THE HILLS SHIRE COUNCIL

Our Ref: 56/2024/PRE
Your Ref: PAE-97925968
SSD-76190964

**Build-to-Rent Housing, Co-Living Housing and Commercial Development
Lot 19 DP 280013, Tempus Street, Rouse Hill (Rouse Hill Town Centre)**

Basement 2 Plan

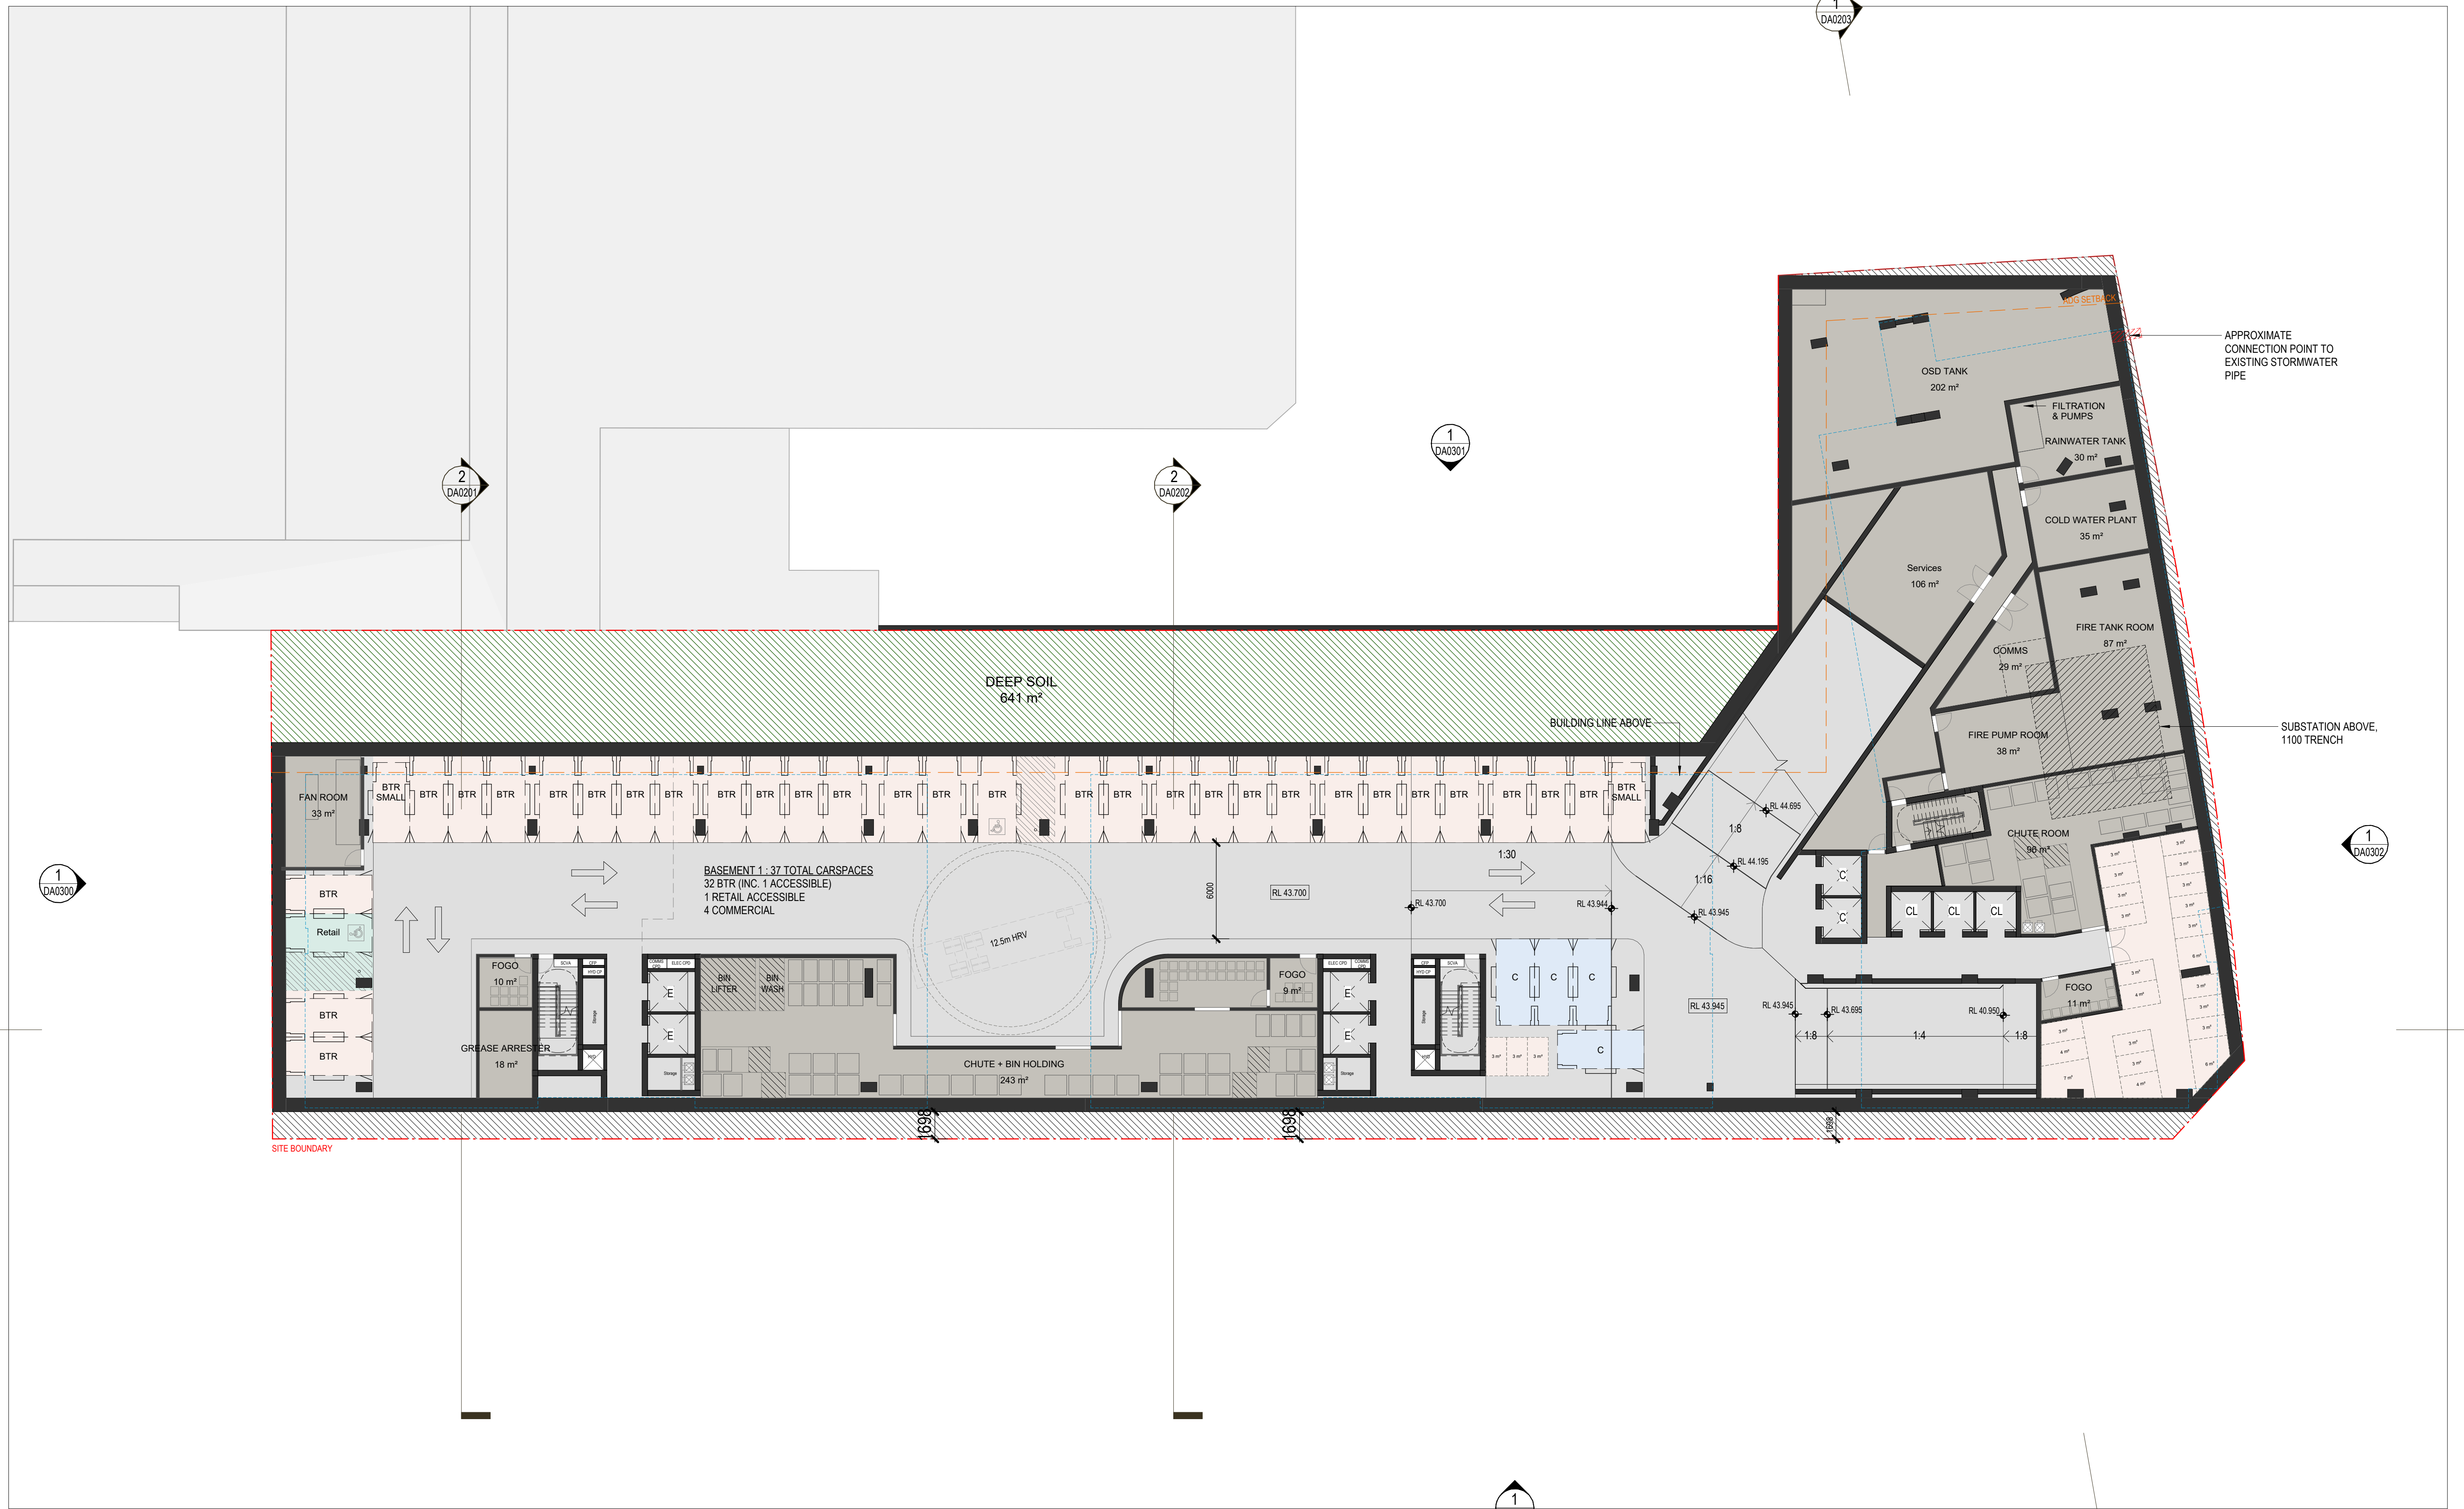
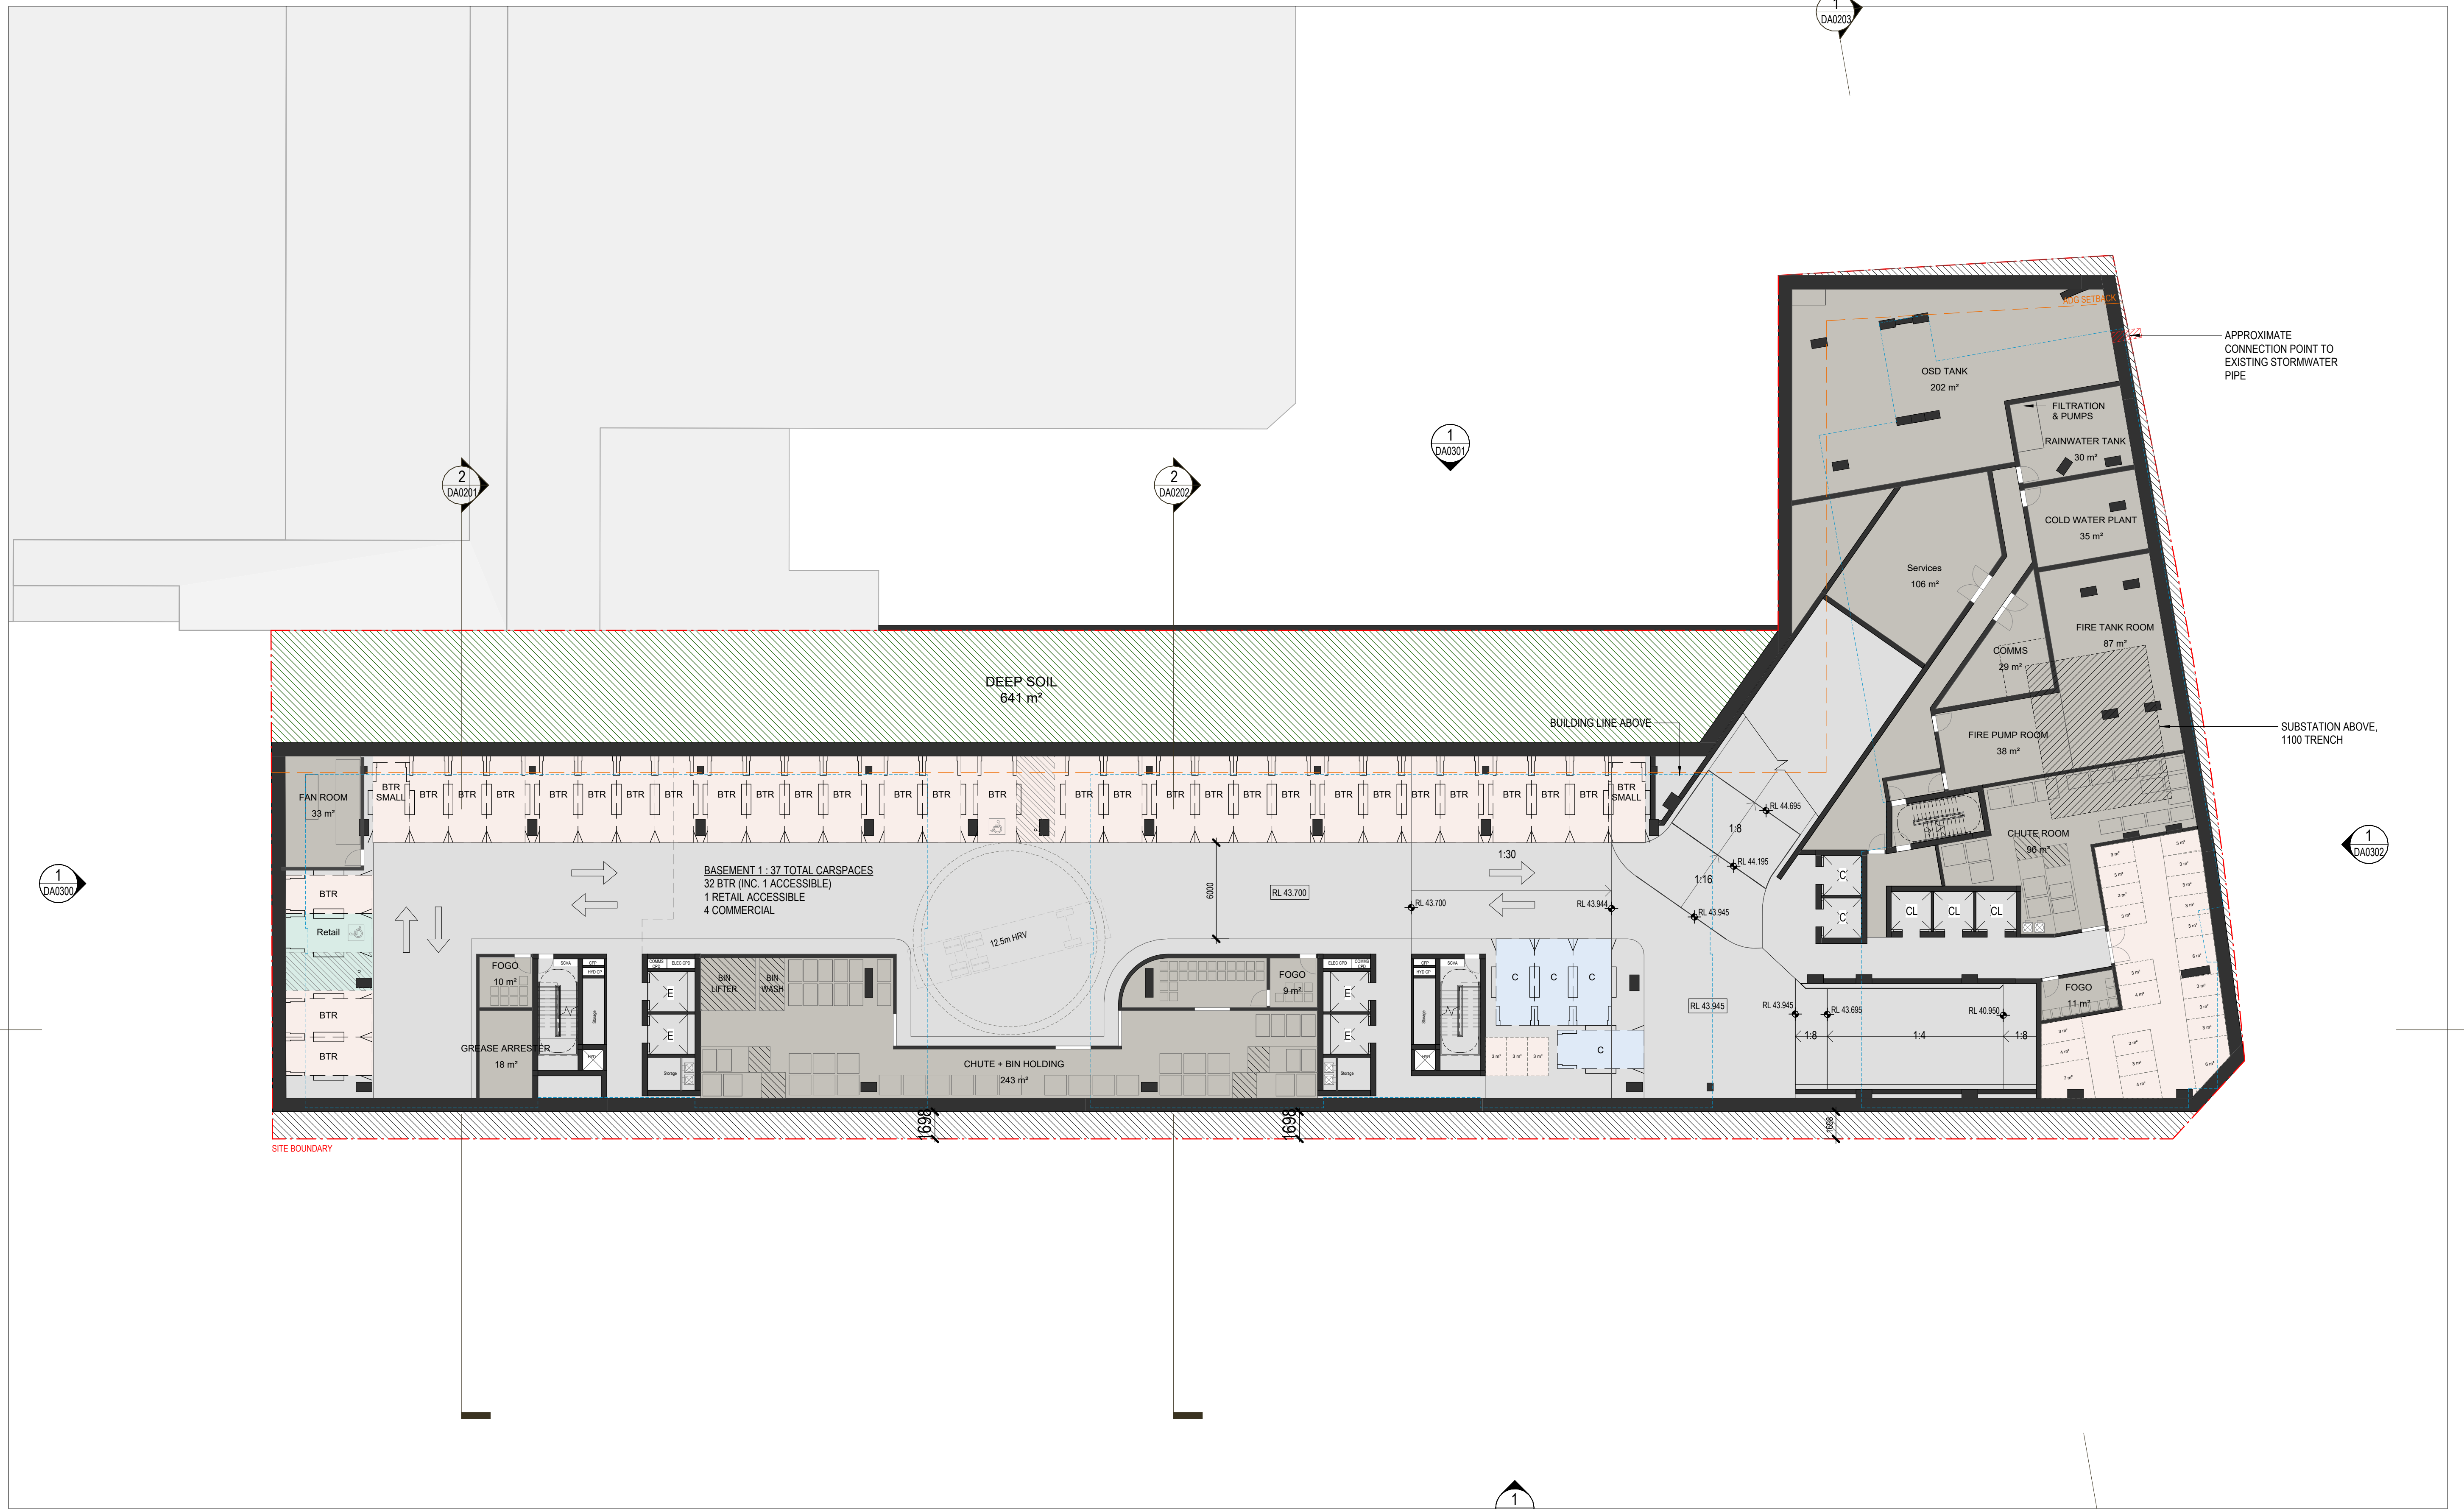
- b. The residential bulky waste room is located in basement 2. This must be relocated to be on the same level and open directly onto the loading area. This is because Council's bulky waste collection service will be conducted onsite with collection staff accessing the items directly from within the room. The proposal for the building caretaker to transport bulky waste into the bin holding room on basement 1 is not supported as:

- c. The commercial bin room is located in basement 2. This must be relocated to be on the same level and open directly onto the loading area. The commercial bins must not be placed in the residential bin holding room, and similar to the reasons in point (b) above, if presented at the loading area, will conflict with truck manoeuvring space and turntable operations.
